From: Conan Sturdy
Sent: 07 June 2022 11:05
To: Amber Willard
Subject: Re: lu/79/22/pl

LU/79/22/PL at The Old Printworks.

PROPOSED ROOF TERRACE COMPUTER GENERATED VISUALS FOR REFERENCE

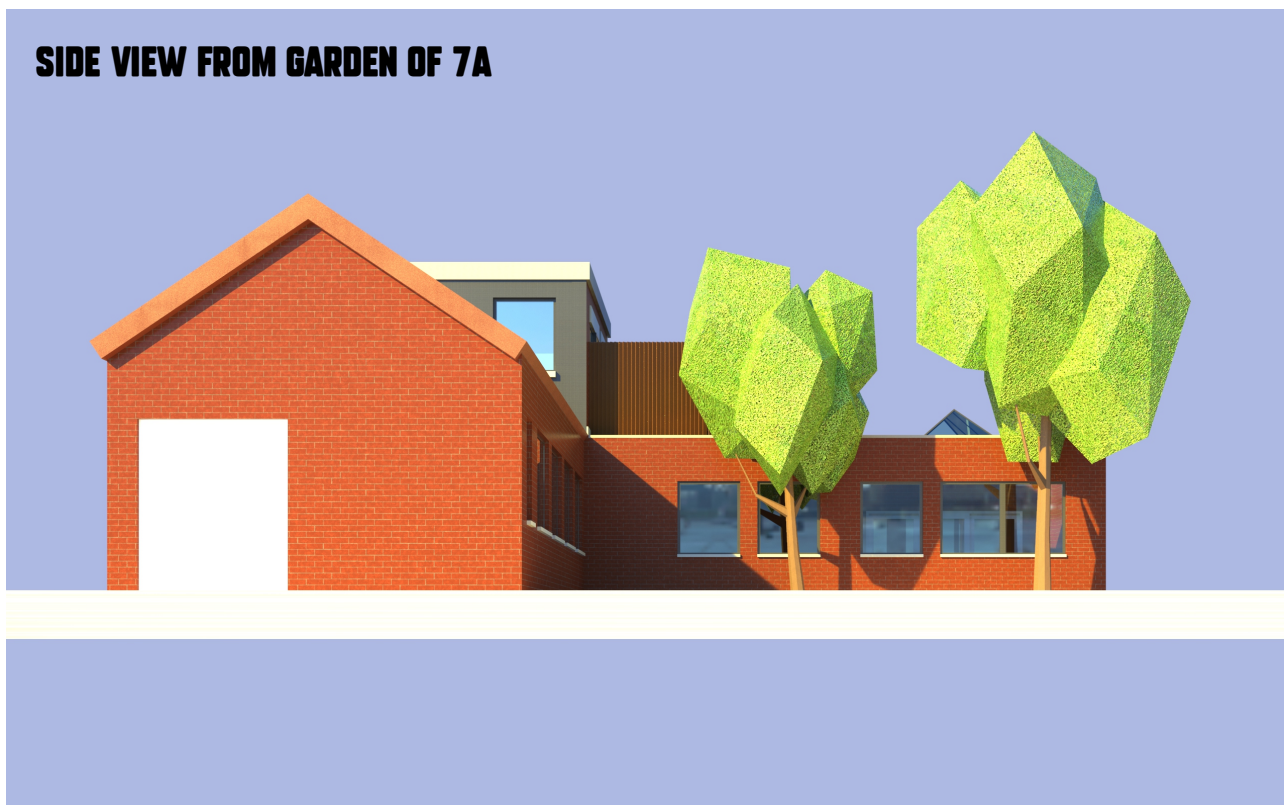
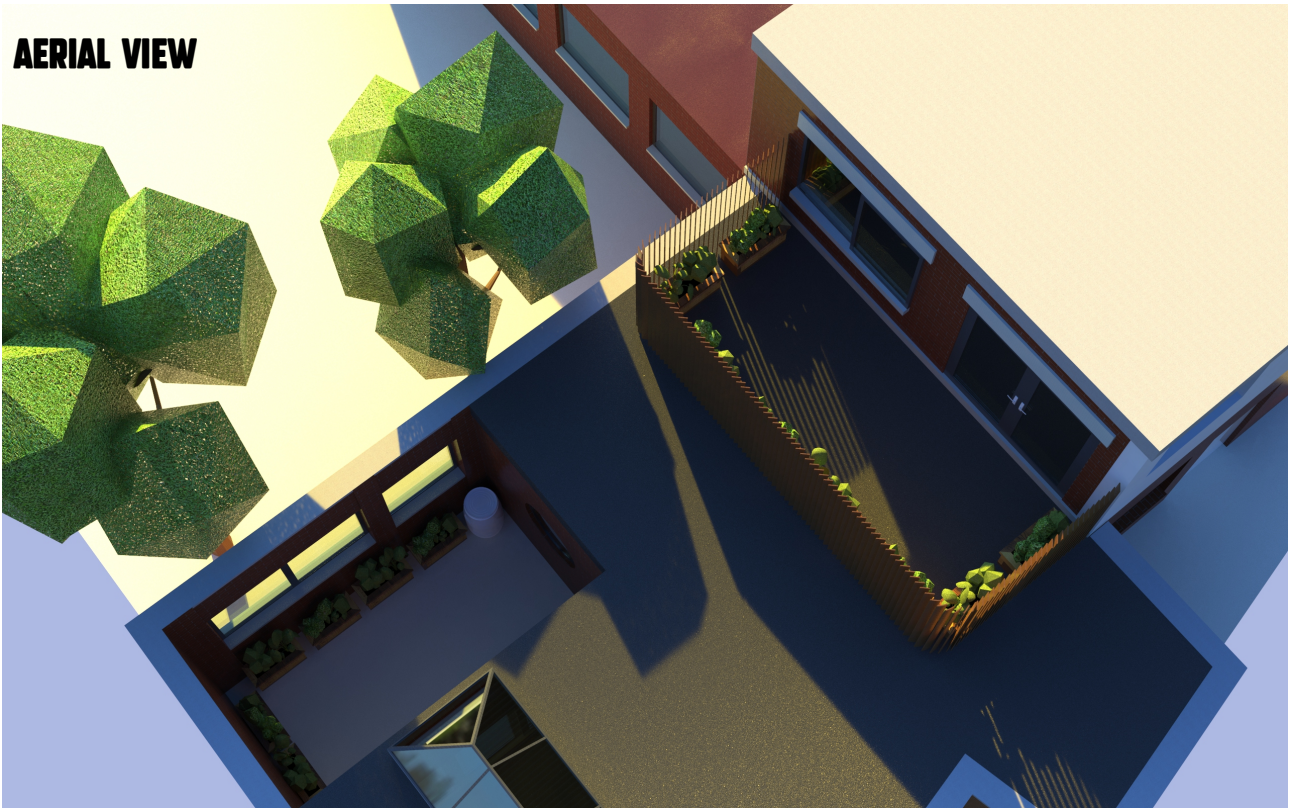
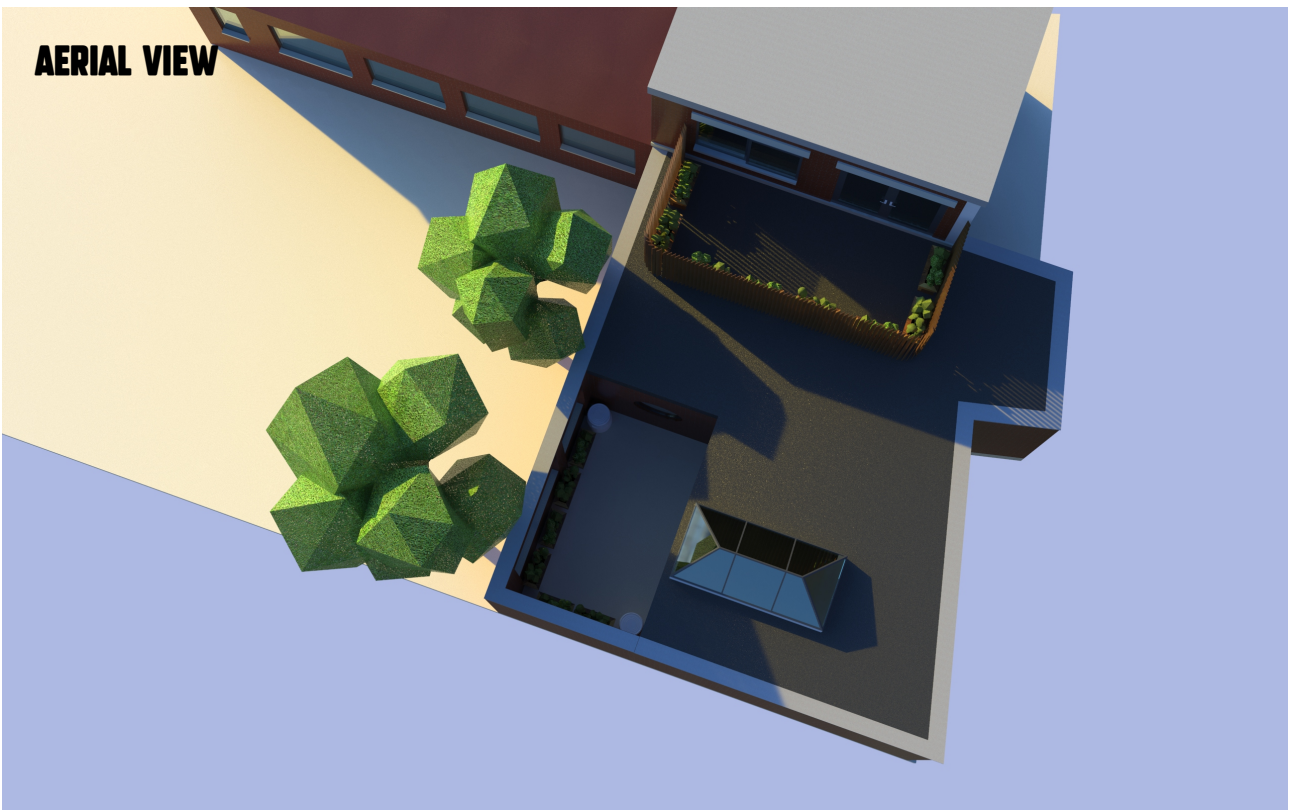
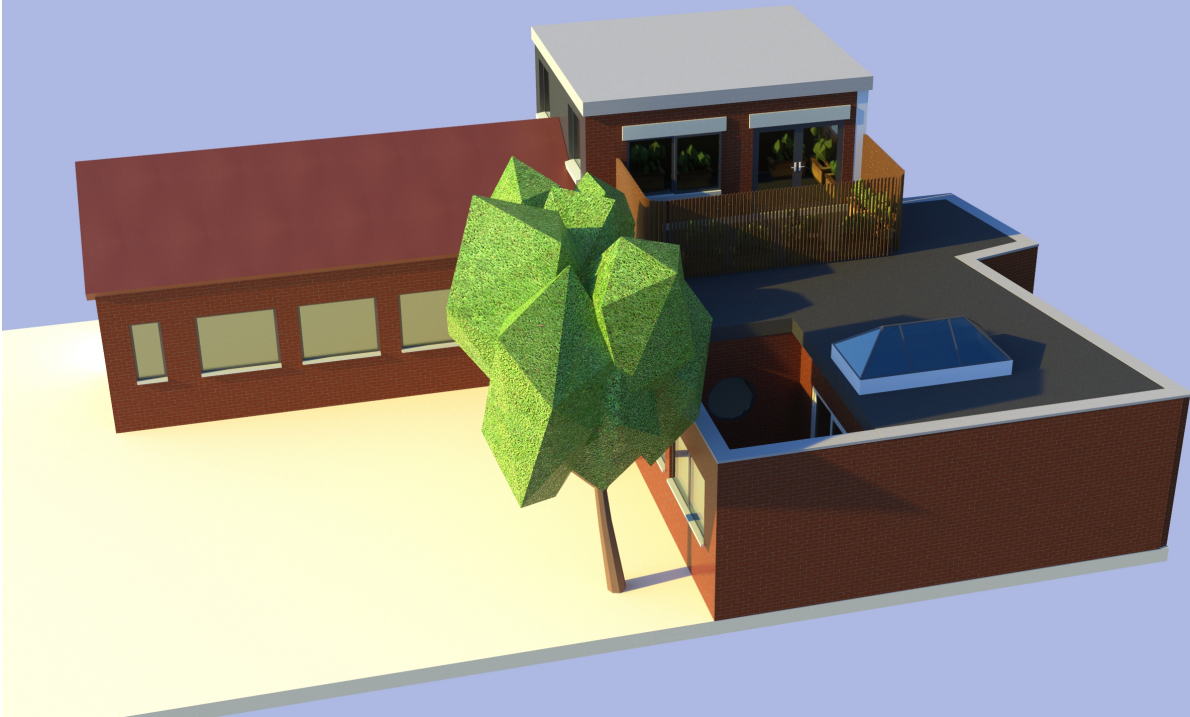
I did receive the email although I believe the roof terrace proposed is in this application is not comparable with the balconies to the flats in the vicinity due to their design and location.

I do note there is a small terrace above a conservatory to a property opposite although this is minor in size and does not feature high level screening as proposed which makes it more dominant in appearance.

The current application is not supported by reason of the roof terrace which is out of character. Any alterations to the scheme would not be accepted under this application and a revised application should be submitted incorporating the removal of the roof terrace. With this element removed it would likely be supported.

I will resubmit by the end of the week with the roof terrace deleted, a slightly different front door and one more porthole. I'll get the amended drawings over and revised planning statement ASAP. Hopefully there will be no charge ? Thanks for your input

The team leader has advised a withdrawal and resubmission following the removal of the terrace alternatively a refusal will be issued. Please let me know if you wish to withdraw.

I advise you withdraw this application and resubmit with the changes mentioned. You may be able to get a free go if you've not had one previously. Alternatively it will be refused.
